CHENNAI METROPOLITAN DEVELOPMENT AUTHORITY

File No. : CMDA/PP/NHRB/C/0791/2019

Sub : CMDA-Area plans Unit - 'B' Channel (Central) – The Planning Permission application received for the proposed construction of 1Parking + 9Floor Residential building with 6 dwelling units at Door No:C79/ A1,A2,,Plot No:C79/A1,A2,Address:86th Street, 18TH Avenue,,Locality:Ashok Nagar,City/Town:CHENNAI in S.No. 70 TS.No. 11 of Kodambakkam village within the limit of Greater Chennai Corporation Particulars called for - Reg

CAR PARKING - 17 Nos

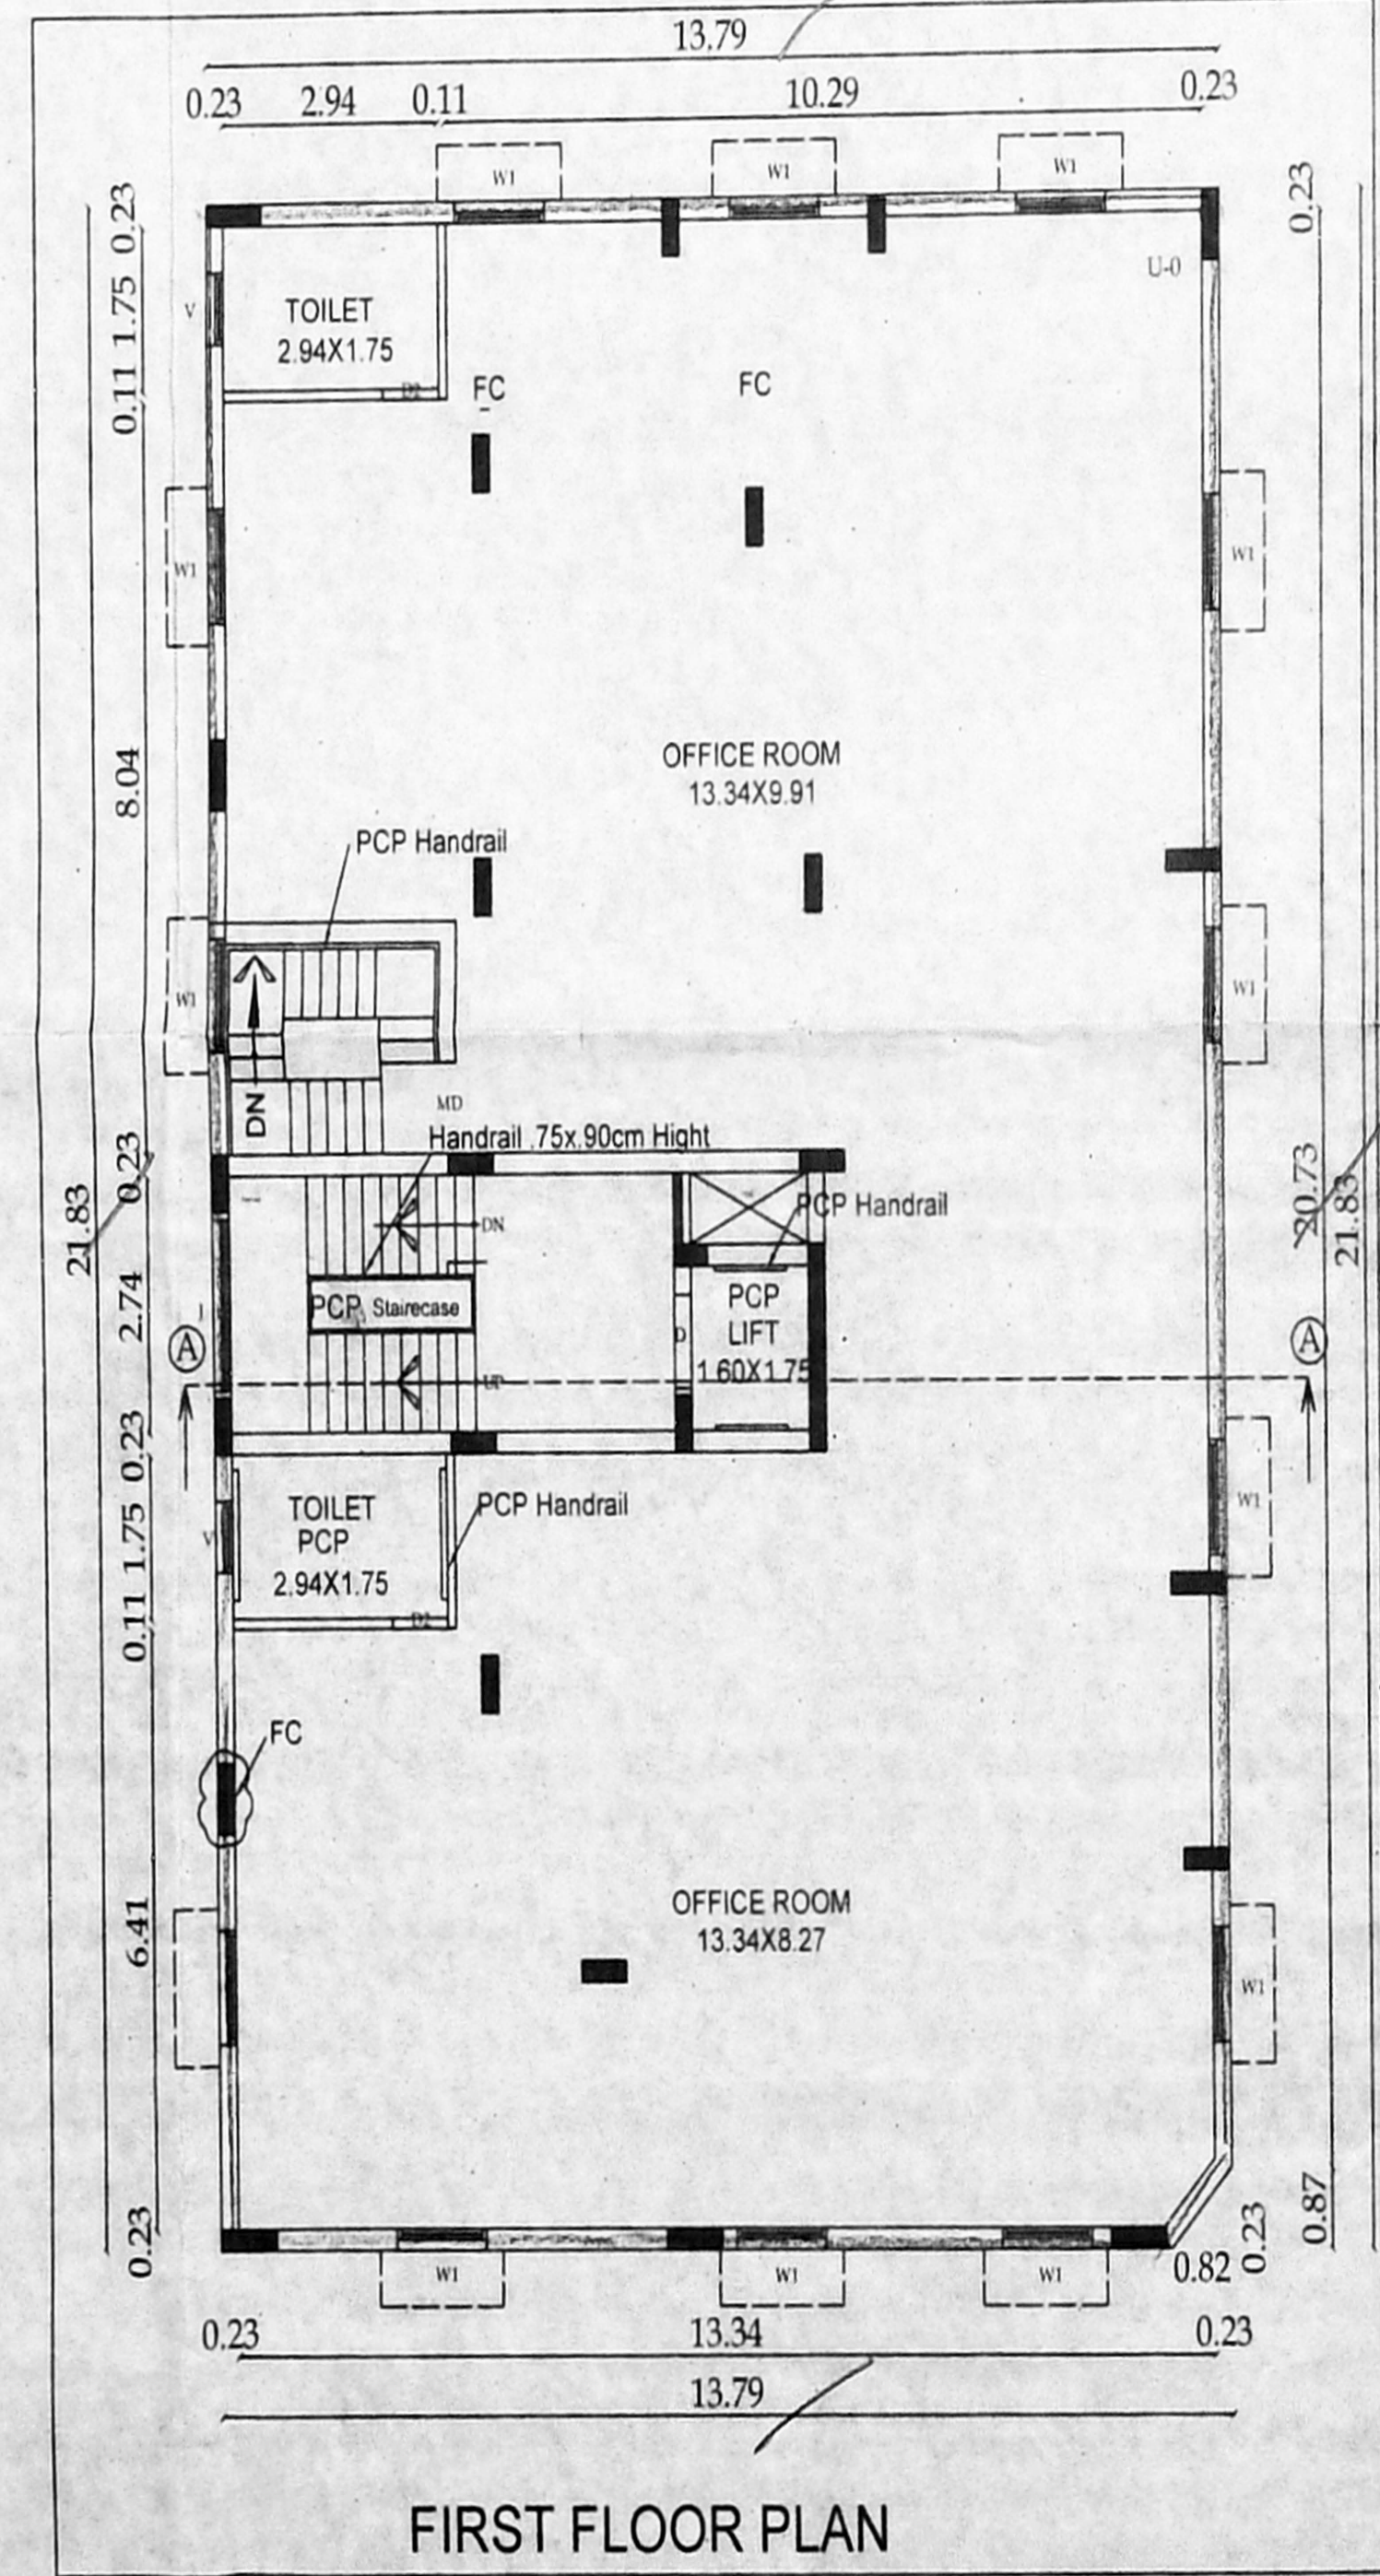
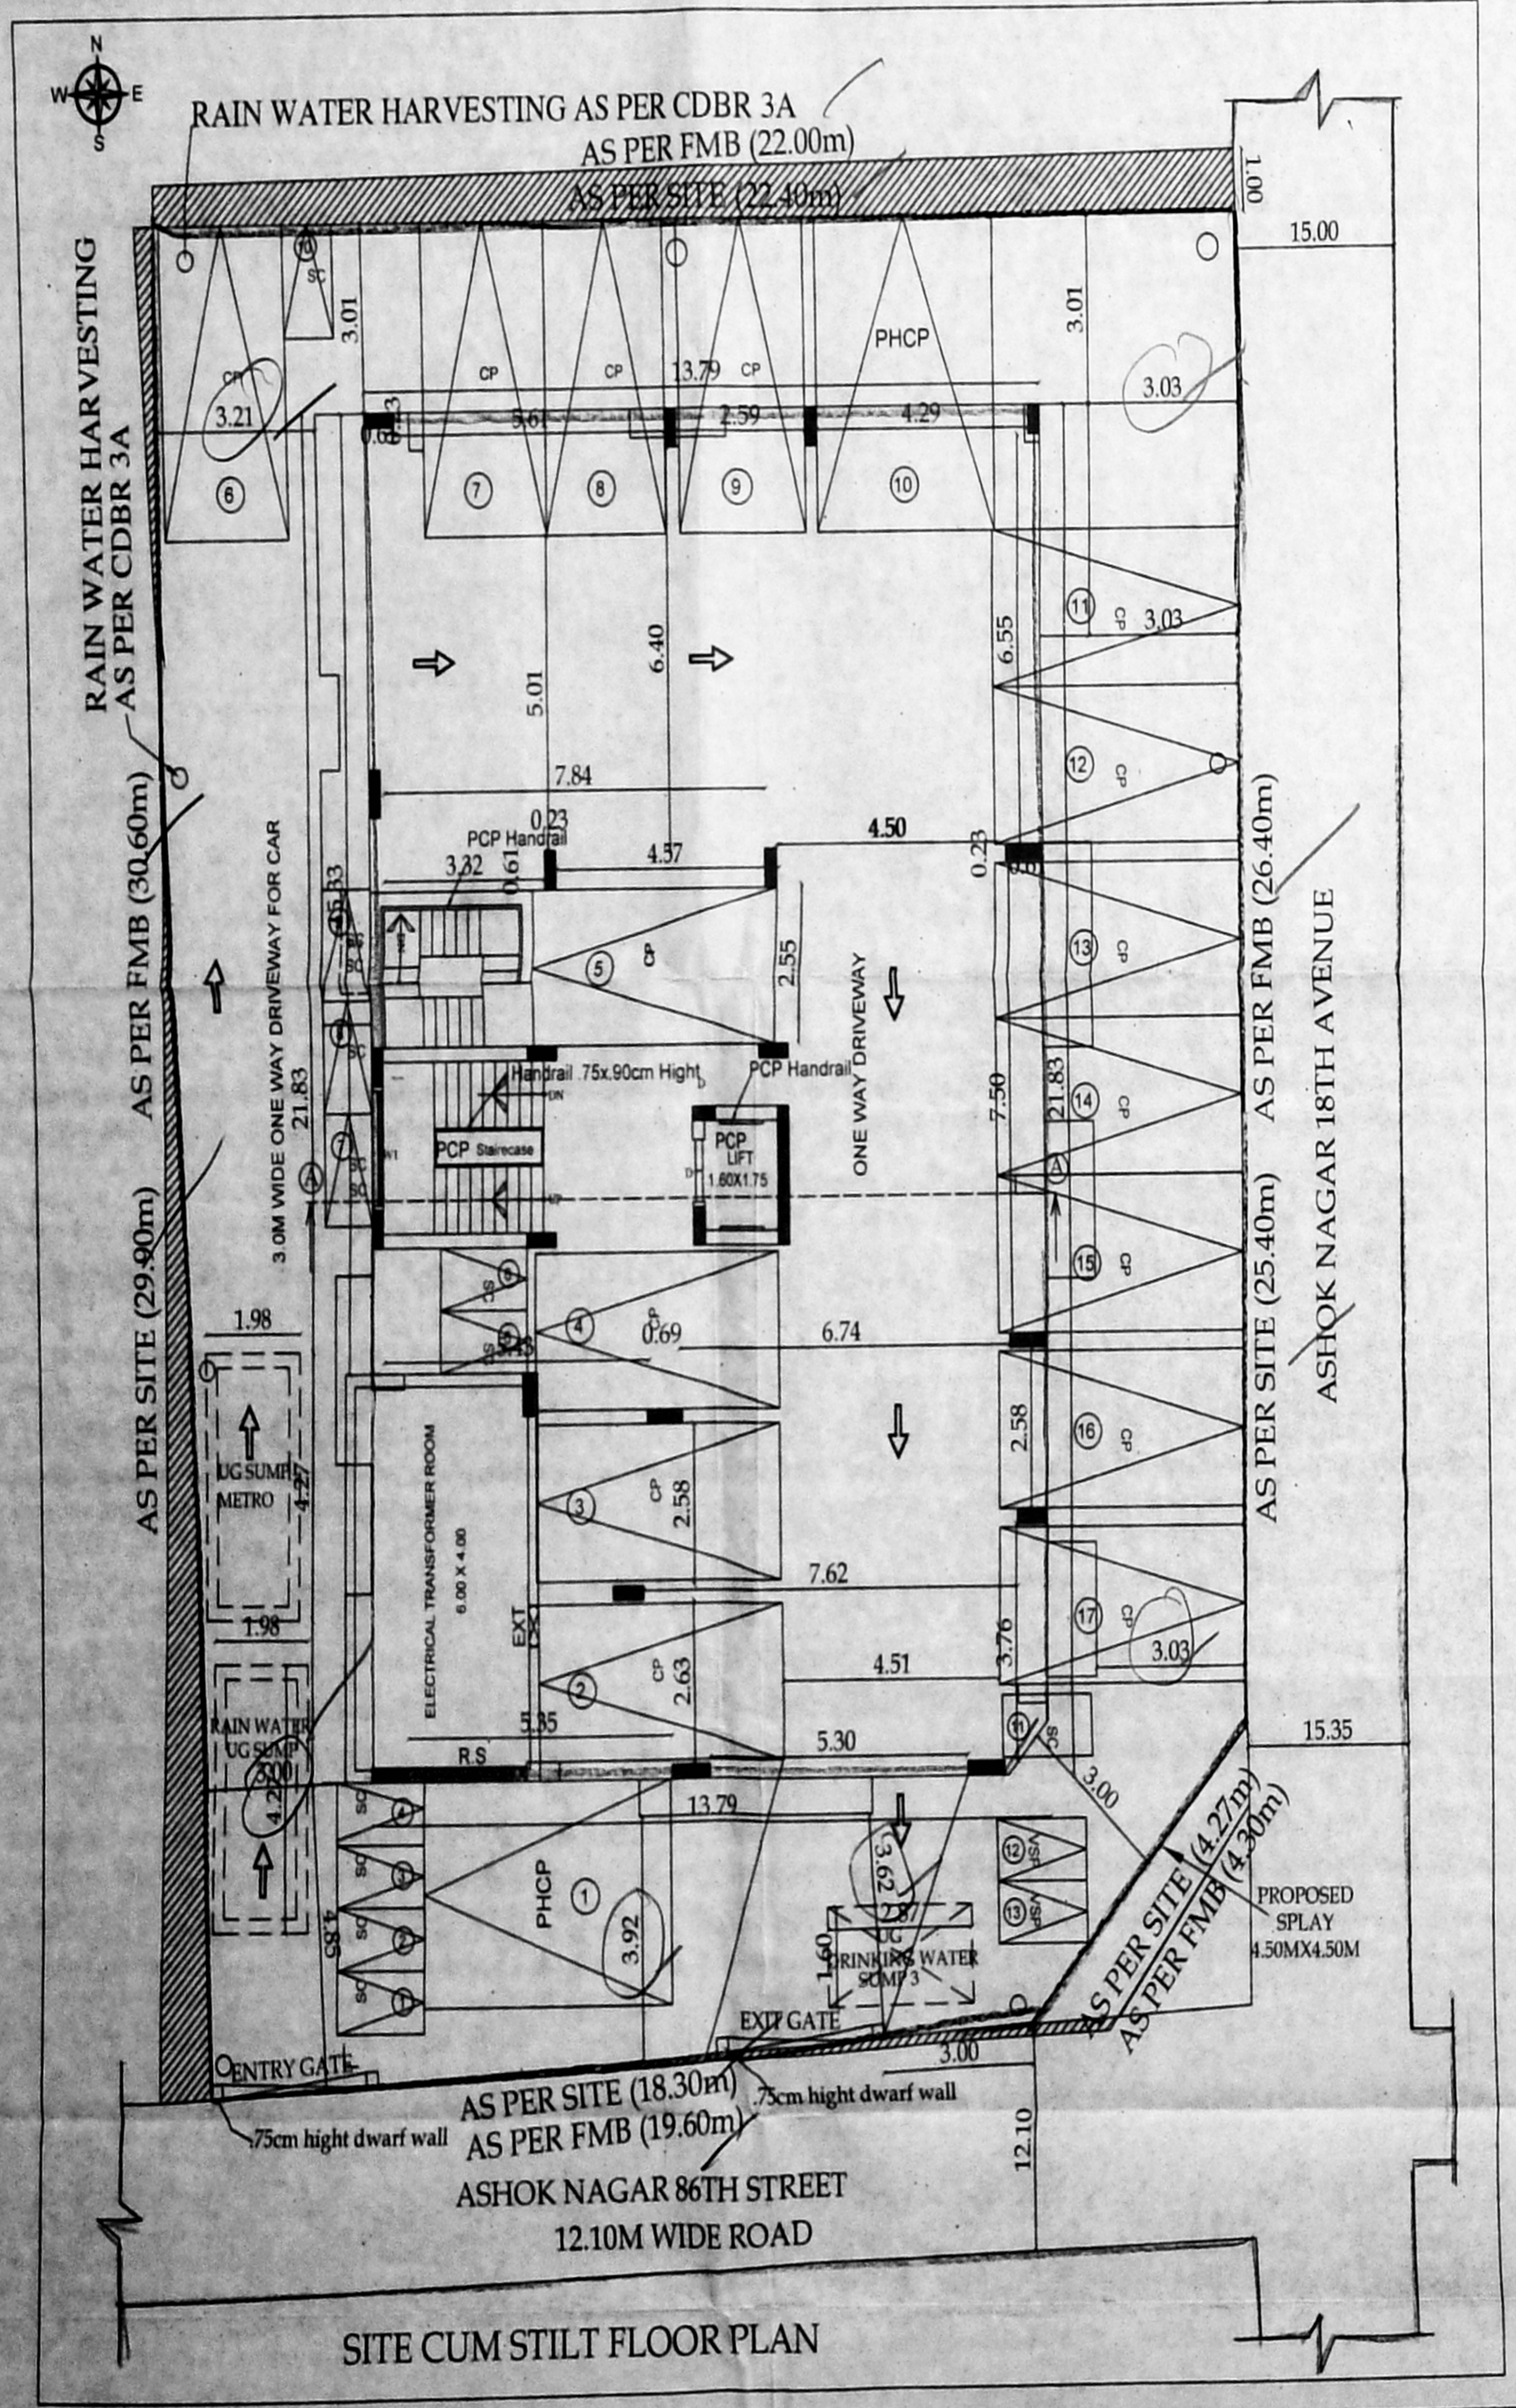
- 1.17 Nos of Car parking 13 Nos of T.W.Parking to be shown correctly
- 2.Title and Area statement to be shown correctly.
- 3.Setback details to be shown correctly.
